From:
Sent: 28 December 2024 20:18
To: DC Admin
Subject: Application number 2024/93341

Planning application 2024/93341_Erection of extension to detached garage block, raising of roof height and erection of front dormer, with associated alterations at 54 Wellhouse Lane, Mirfield WF14 0PW

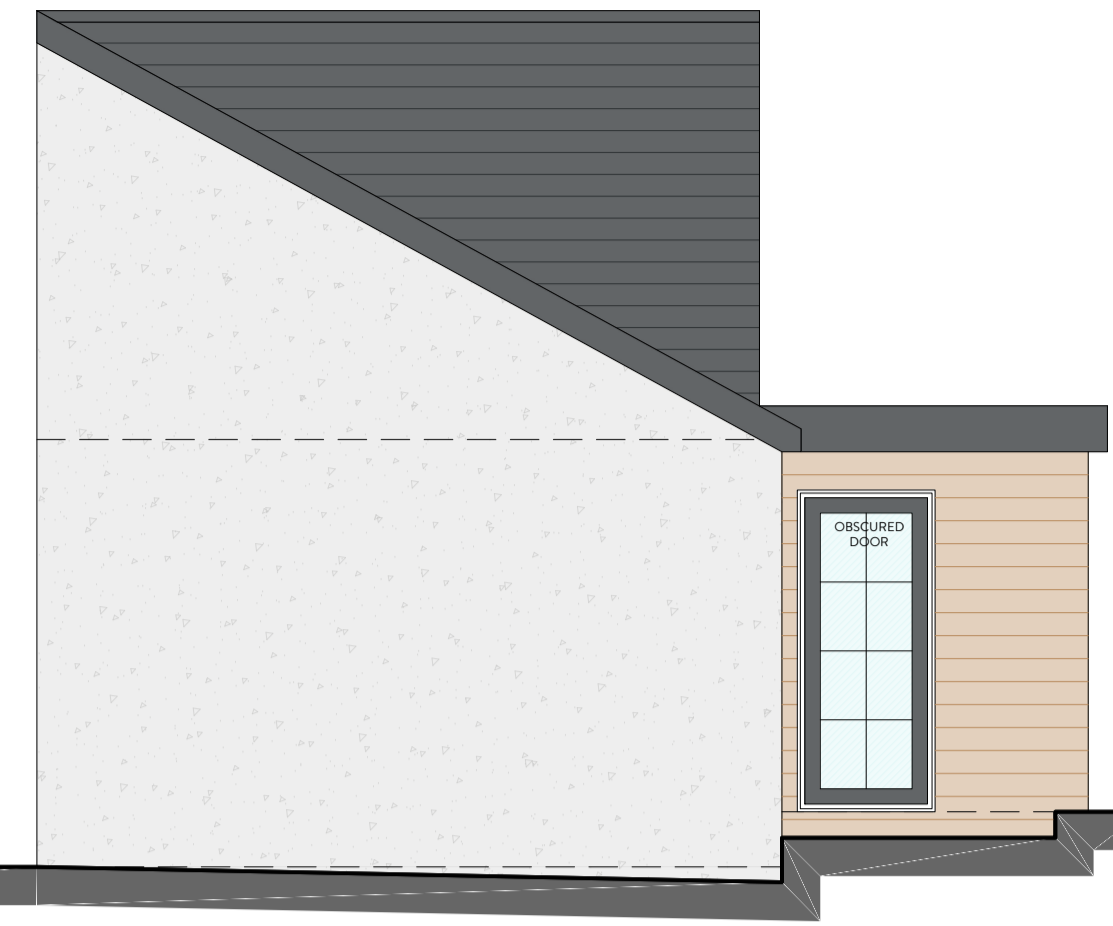
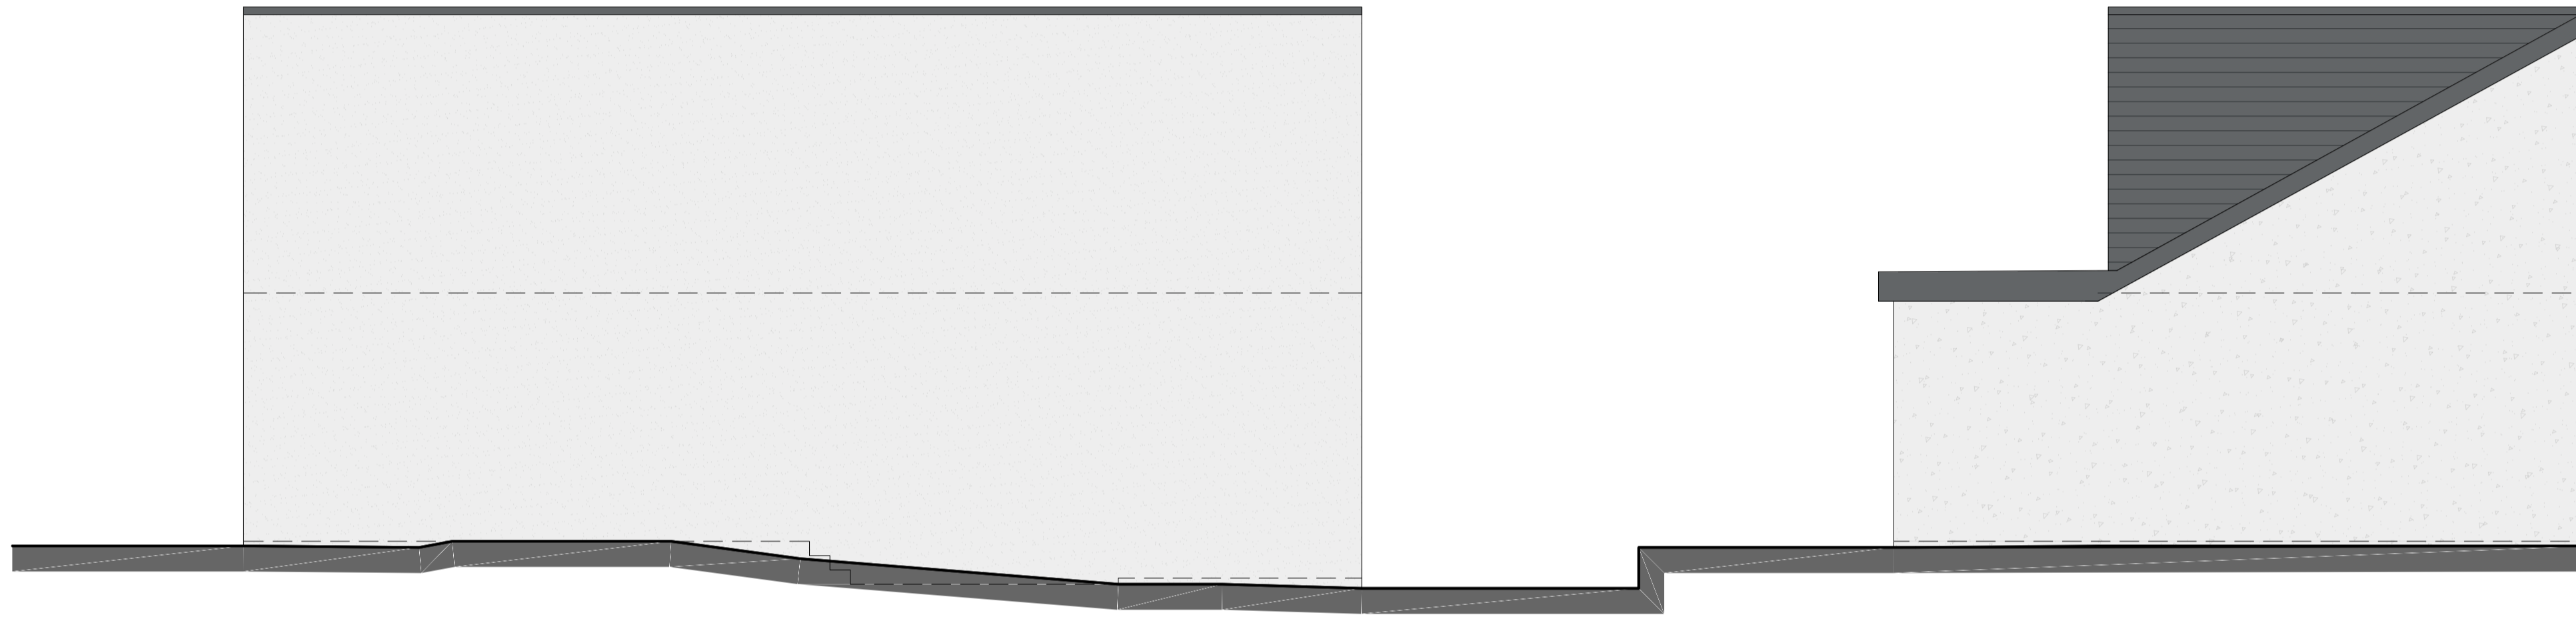
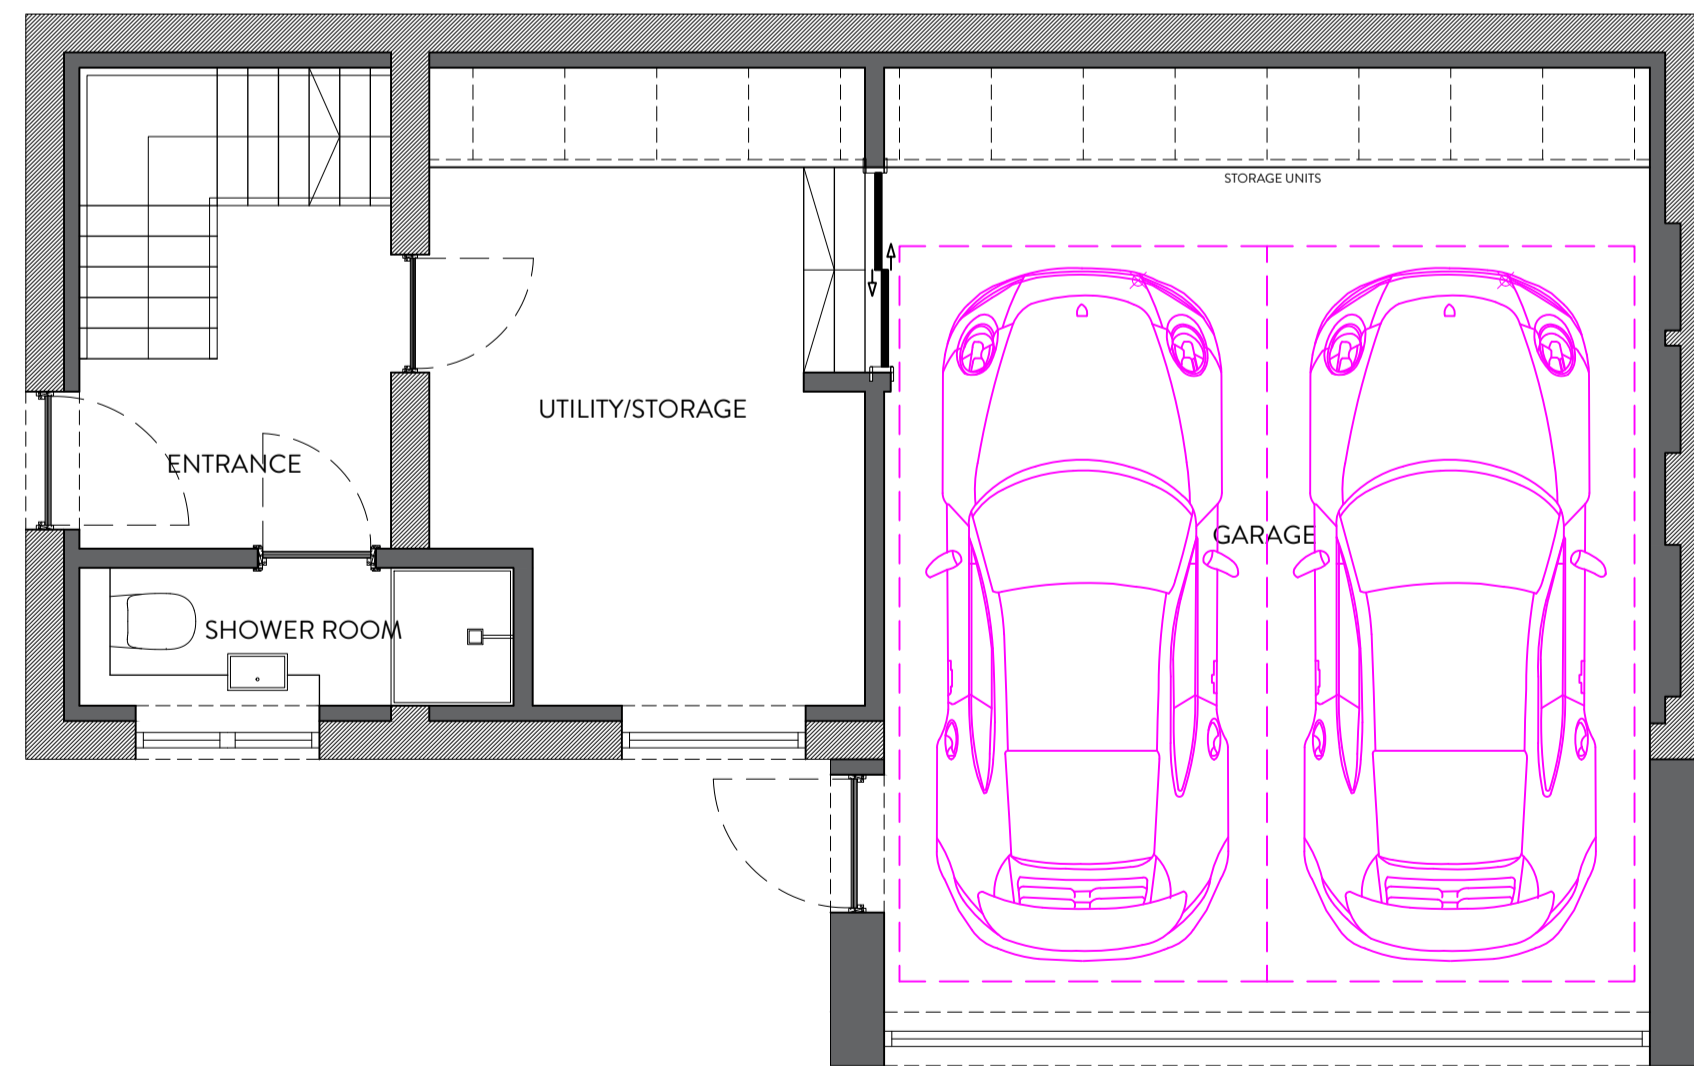
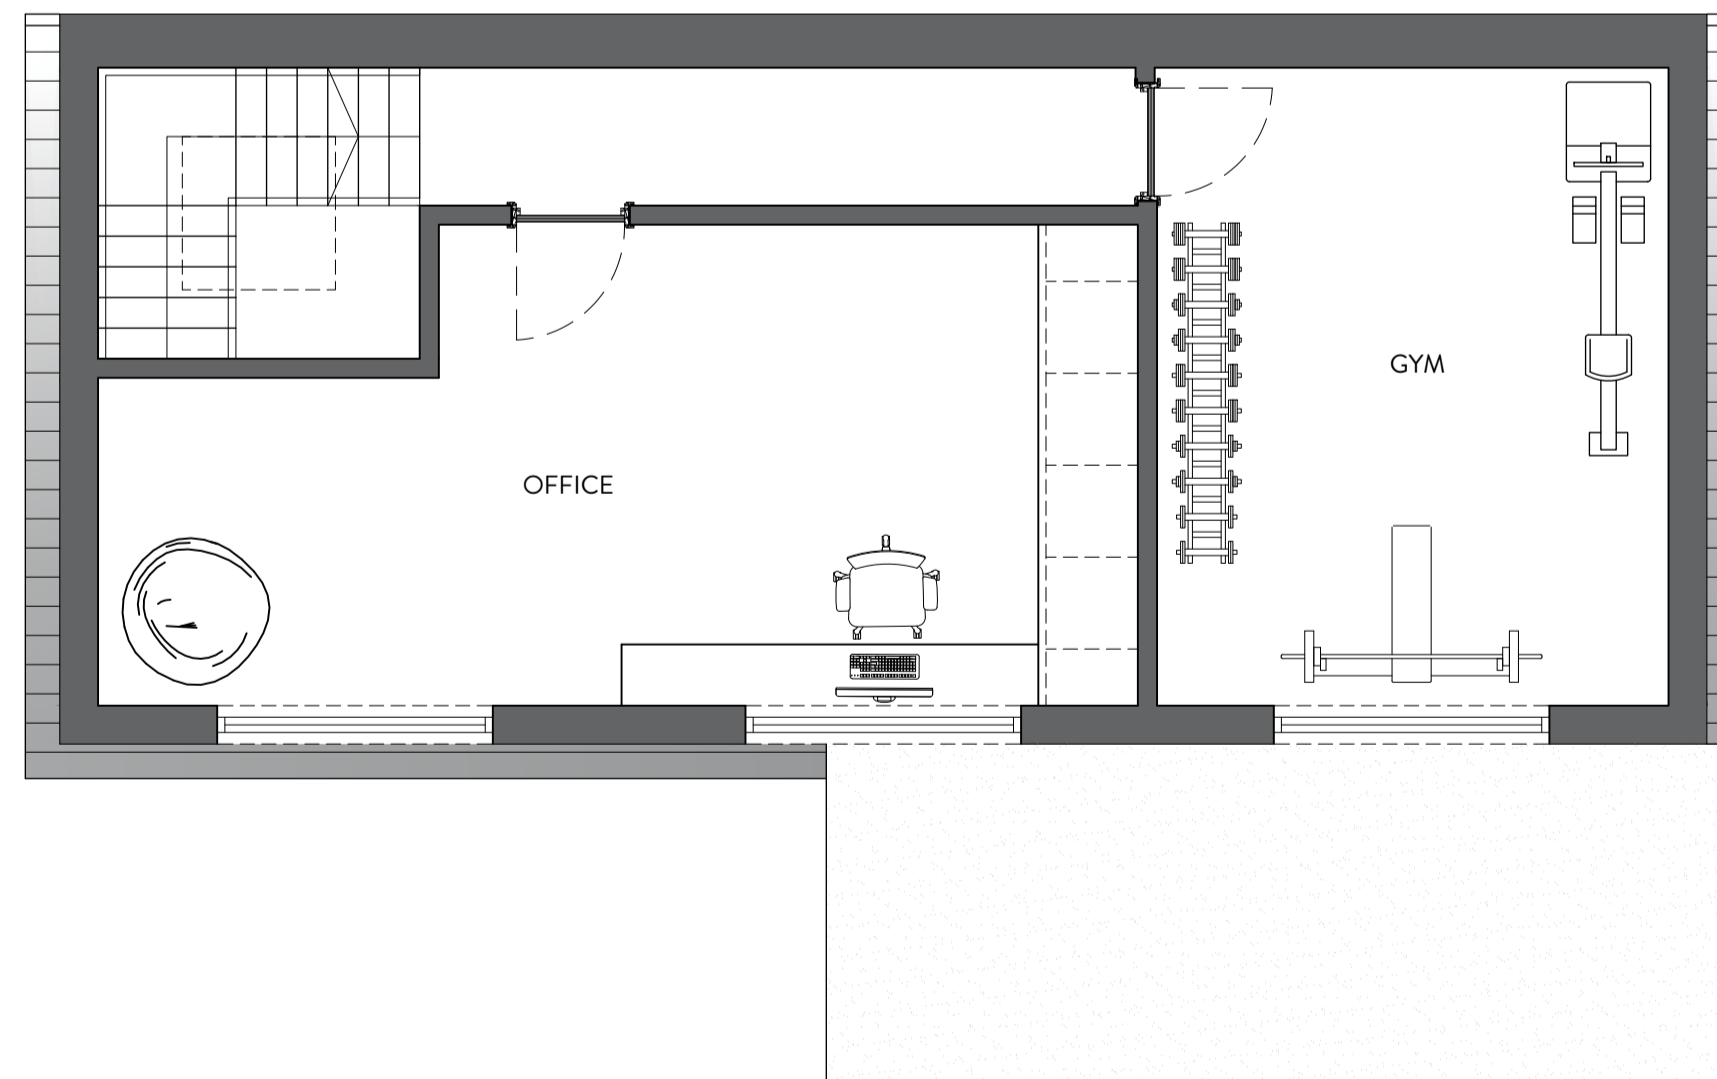
The proposed side and rear elevations are both located on the plot boundary and will offer overbearing two storey blank elevations to the surrounding dwellings. The property to the rear is only separated from the elevation by 6 metres exacerbated by orientation and the plans don't show the primary bedroom and kitchen habitable windows at 6 Woodward Court. The proposed East side Elevation will shadow and obstruct the existing recreational space at 54A Wellhouse Lane and therefore impact on mental health for all parties effected.

The enlarged footprint at the North elevation brings the parking and access apron into direct conflict with the access drive to 54A Wellhouse Lane. This access is protected by a covenant stating that this area cannot be obstructed temporarily or permanently, which would occur when accessing the proposed garage. This is the reason that the existing garage door is NOT located closer to the east elevation. The drawing shows increased capacity for vehicles across the gateway of 54A.
